WEST SUSSEX COUNTY COUNCIL CONSULTATION

TO:	Arun District Council FAO: Anita Gardner
FROM:	WSCC - Highways Authority
DATE:	8 April 2022
LOCATION:	Land rear of 1 Sea Drive, Ferring, BN12 5HD
SUBJECT:	FG/54/22/PL 1 No new dwelling. This application is in CIL Zone 4 and is CIL Liable as new dwelling.
DATE OF SITE VISIT:	N/A
RECOMMENDATION:	Advice
S106 CONTRIBUTION TOTAL:	N/A

GROUND FLOOR PLAN

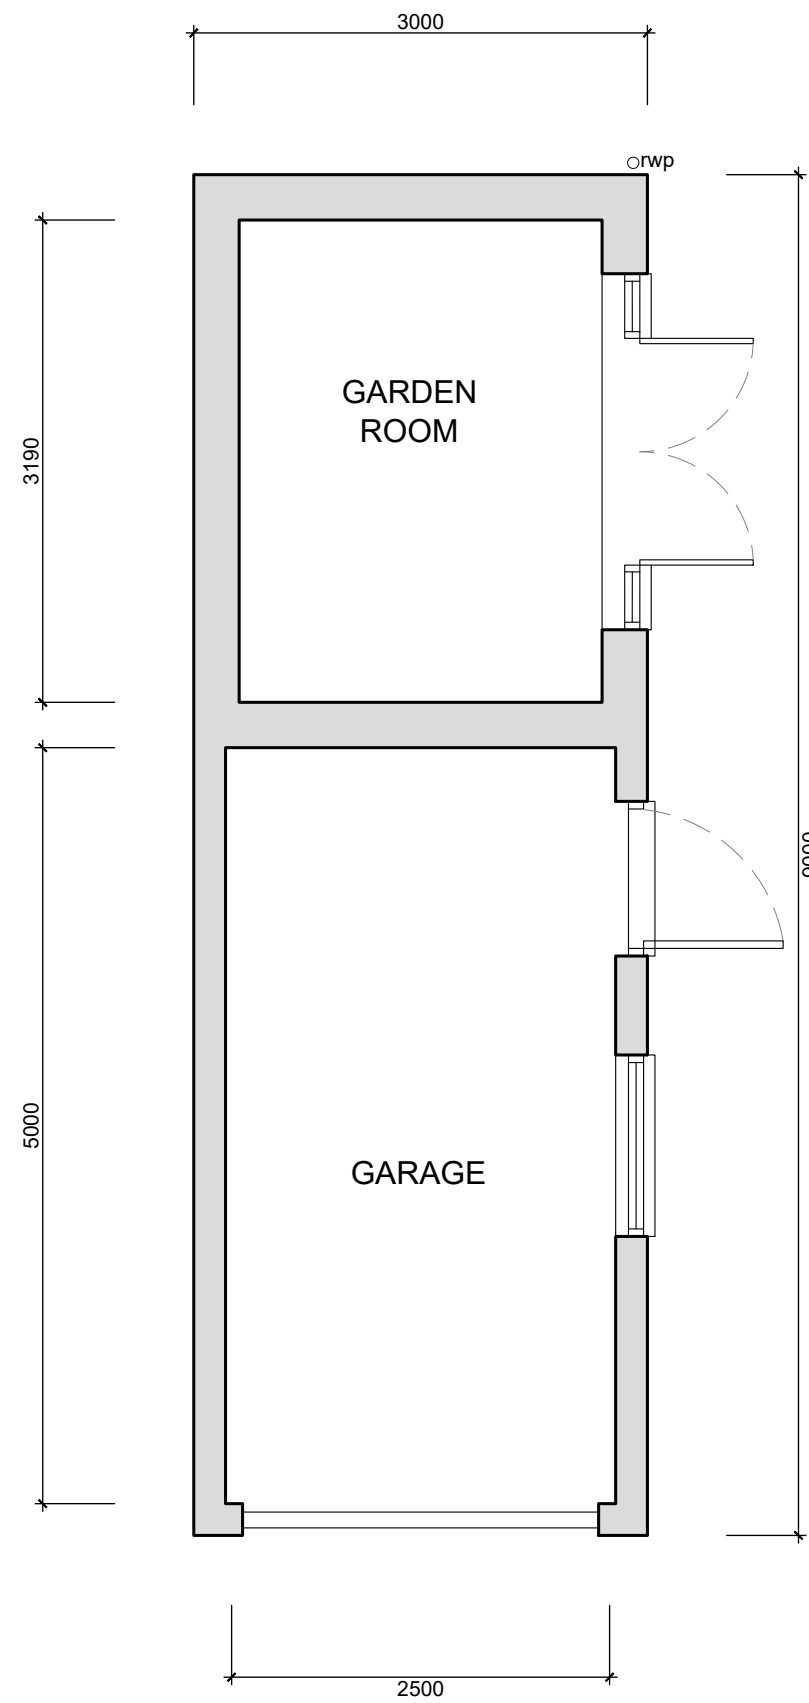
The LHA does note that the proposed garage does not meet the minimum internal specifications for single-bay garages of 3m x 6m as set out in Manual for Streets (MfS). The applicant is advised to enlarge the garage to MfS specifications to ensure modern cars can be accommodated inside.

Proposed Site Plan
Scale 1:100 @ A1

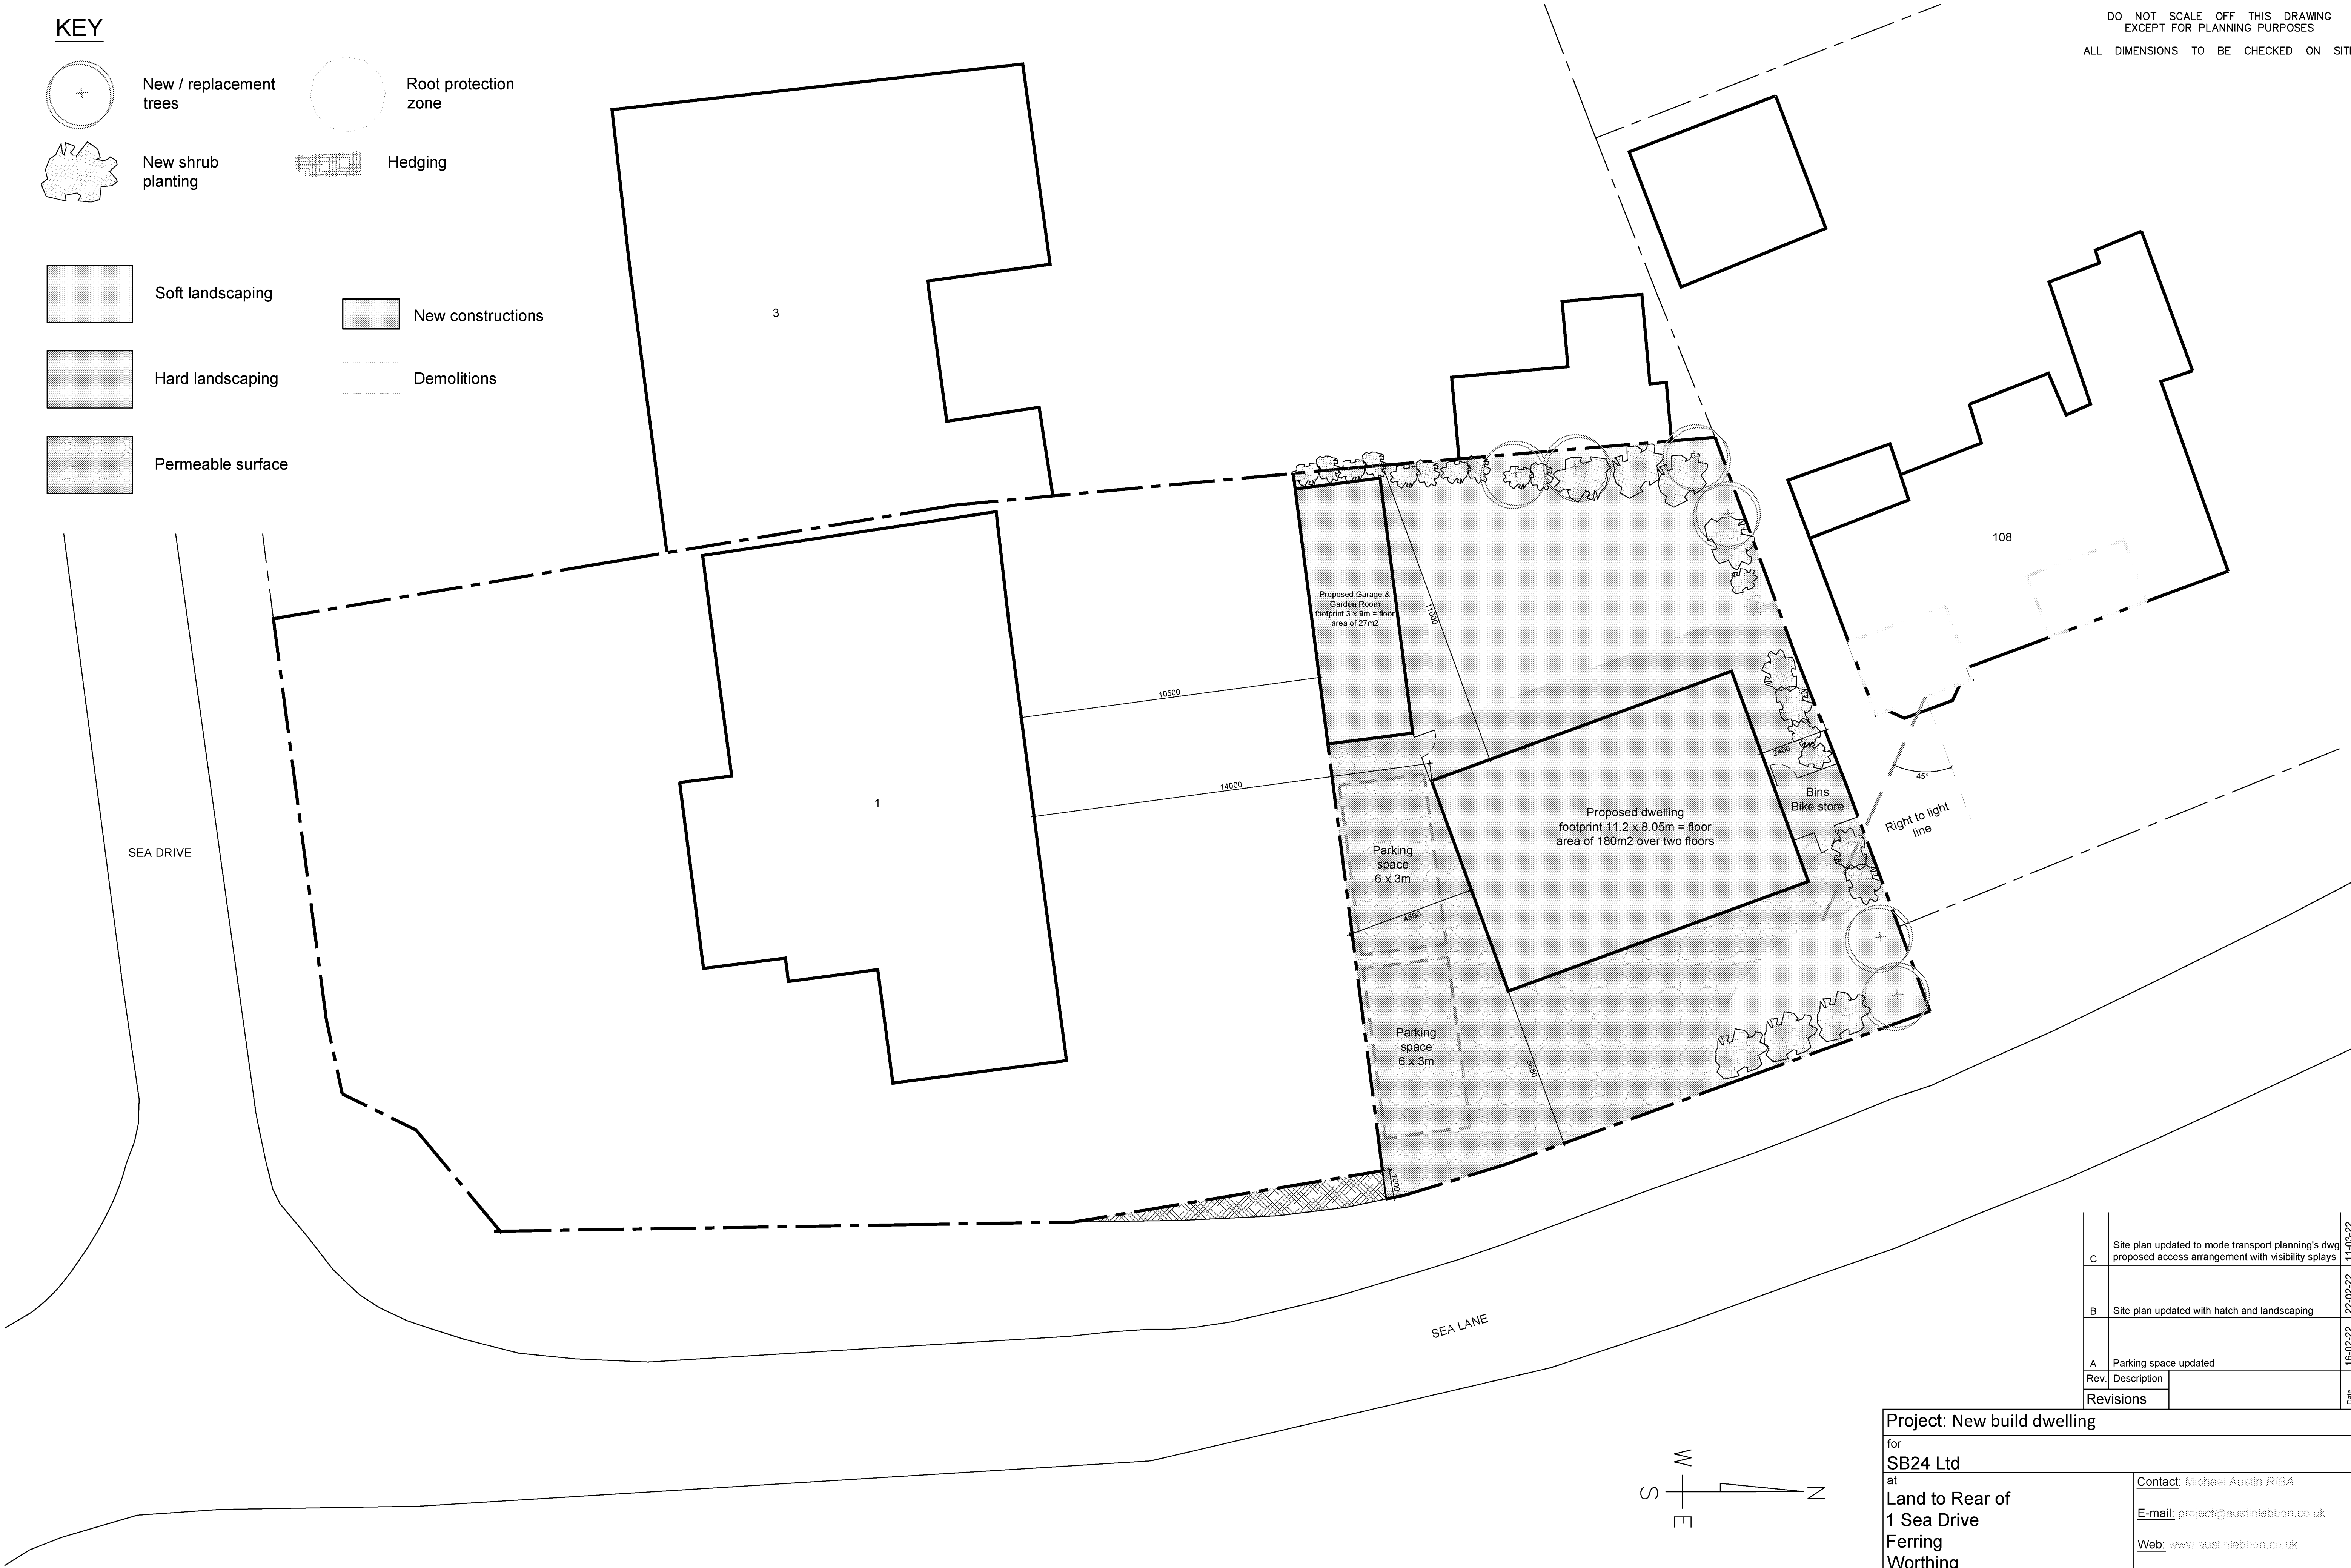
The applicant proposes a new vehicular access on Sea Drive. The proposed access works will be subject to a vehicle crossover (VCO) licence obtained through the local Highways Area Office and constructed to a specification agreed with the local Highways Area Engineer. The applicant should be aware that VCO licences are granted for accesses up to a maximum width of 6.4m. Therefore, the applicant is advised to reduce the access width to at least 6.4m.

On-site turning does not appear achievable, so vehicles may have to exit the site in a reverse gear. However, this is not anticipated to result in an adverse highway safety impact, owing to sufficient visibility either side of the access.

Proposed Access Arrangement

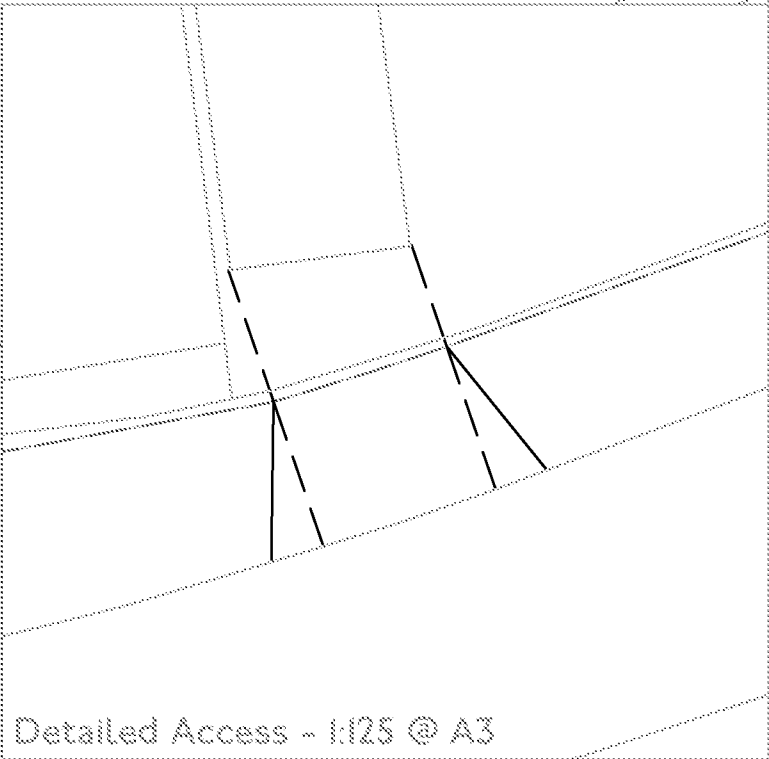
Vehicular visibility has been demonstrated in Appendix B of the Technical Note, with splays of 2.4m x 43m achievable in both directions, in accordance with Stopping Sight Distances (SSD) for a 30mph speed restriction.
